WEST SUSSEX COUNTY COUNCIL CONSULTATION

TO:	Arun District Council FAO: Maria Tomolova
FROM:	WSCC - Highways Authority
DATE:	30 July 2020
LOCATION:	Post Office Westergate Street Chichester PO20 3QL
SUBJECT:	AL/53/20/PL Change of use from residential (C3) to shop (A1), new roof & new shop front. This application is in CIL Zone 2 (Zero Rated) as 'all other development'.
DATE OF SITE VISIT:	n/a
RECOMMENDATION:	Advice
S106 CONTRIBUTION TOTAL:	n/a

PROPOSED SITE PLAN (NO CHANGE)
scale 1:500

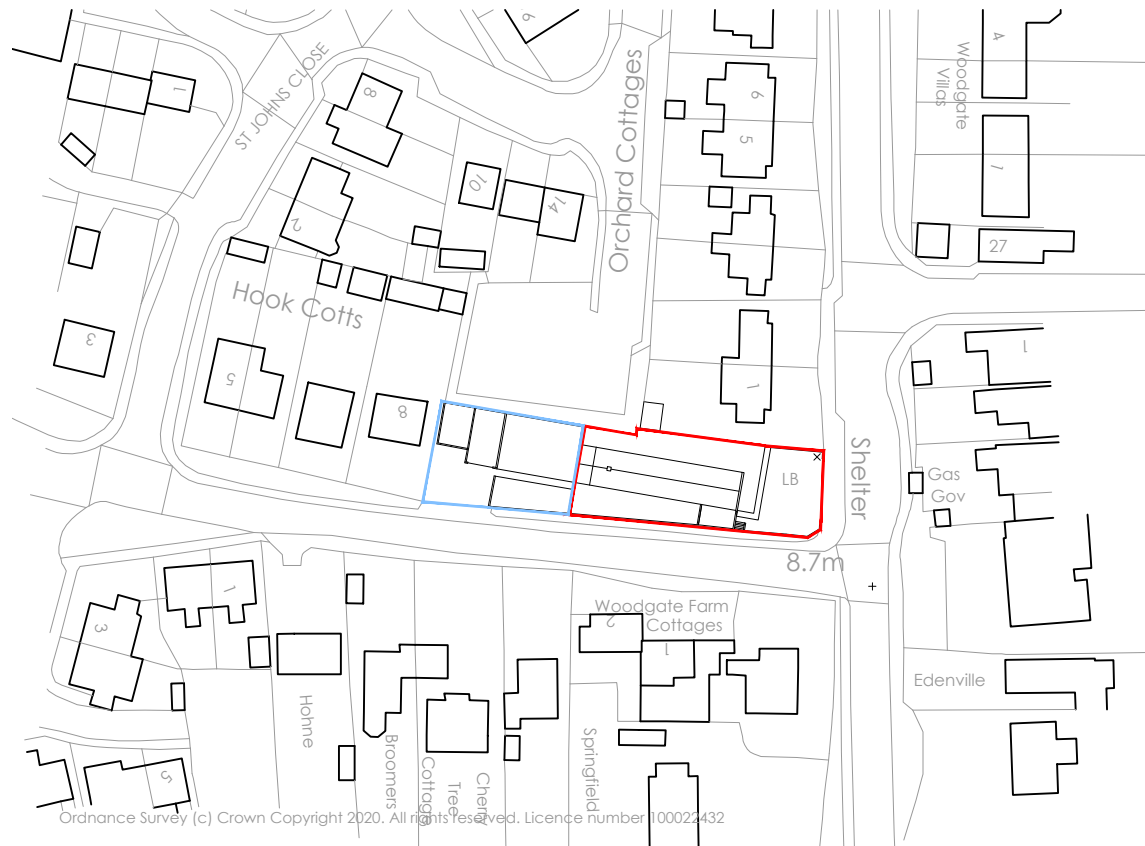
The provided plan indicates that the applicant proposes to formalise the parking arrangements on site to provide 5 parking spaces, including one disabled parking bay. Each space appears to meet minimum specifications of 2.4 x 4.8m as set out in Manual for Streets, plus additional space for the disabled bay. A turn on site would be preferred to enable vehicles to exit in a forward gear, however it is noted that site constraints may prevent this and the site has been operating this arrangement for some time with out evidence of highway safety concern. The LHA would not anticipate that the proposed additional floor space would result in a severe intensification of use of the site or result in any capacity issues on the public highway.

If the LPA are minded to approve the application, they may wish to consider a condition securing vehicle parking.
